RE: 2020/60/92331/E - Land east of, Leeds Road, Chidswell, Shaw Cross, Dewsbury

Thank you for consulting Yorkshire Wildlife Trust. Our most recent comments on this application were in January 2021. Since that time a number of new ecological documents have been submitted in relation to the application. We have reviewed these documents and have the following comments:

Figure 2 Pre-development habitats.

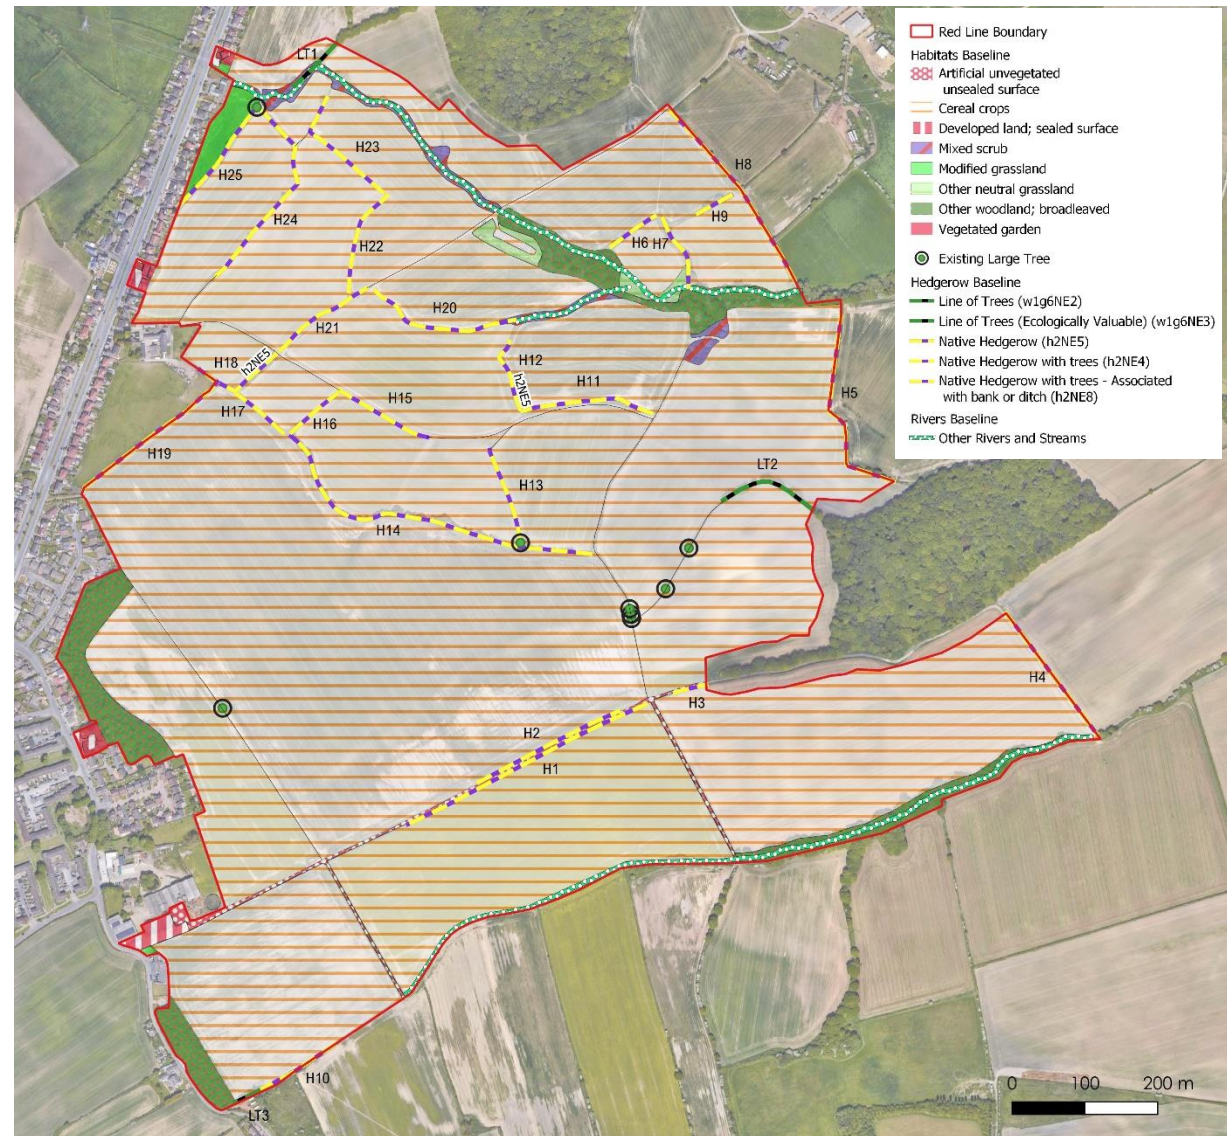
Assumptions have been made but it is not clear when the survey information to support these assumptions was collected, or by whom? Was a river assessment undertaken as part of the updating walkover survey in October 2022 (which the report acknowledges is outside the optimum survey period). No information is included in Appendix 1 – Habitat Baseline information & Condition Assessments about the river assessment which has taken place.

We appreciate that this is a high-level document due to the fact that the application is an outline planning application. However, it is not appropriate to make such assumptions with regard to the baseline condition of the site and we request that the River Metric calculations are undertaken prior to determination of the planning application. The survey must be undertaken by an appropriately trained and qualified person.

We note that the river forms part of the Kirklees Wildlife Habitat Network (KWHN) and therefore should be assessed as the highest strategic significance criteria in the metric – at present it is included as 'low potential/action not identified in any plan'. As the Wildlife Habitat Network has its basis in the Local Plan (Kirklees Policy LP10), the 'within Local Plan' option should be selected. The Defra Metric User Guide (Natural England Joint Publication JP039)¹ states at Paragraph 9.30 that:

'For rivers and streams use the delivery of identified actions within River Basin Management Plans, Catchment Plans and Local Plans to determine high strategic significance'. Amending this option in the metric spreadsheet would alter the baseline units from 12.77 to 14.69 and consequently would reduce the overall River BNG % from 10.20% to 7.76%.

As a further example, adjusting the condition from poor to fairly poor (just one step change in condition) if the current condition assumption is incorrect would raise the baseline river units from 12.77 to 19.16. This would reduce the BNG % for river units from 10.20% to 3.98%.

It is therefore critical that the baseline river condition is properly assessed as just small variations in the assessment will affect the overall score. The importance of an accurate baseline is clearly laid out within the CIEEM Ecological Impact Assessment Guidelines². Given that the predicted net gain in River Units is 10.20%, any elevation in baseline units would mean that the required 10% BNG would not be achieved. Further confidence is therefore required that BNG for river units can be achieved.
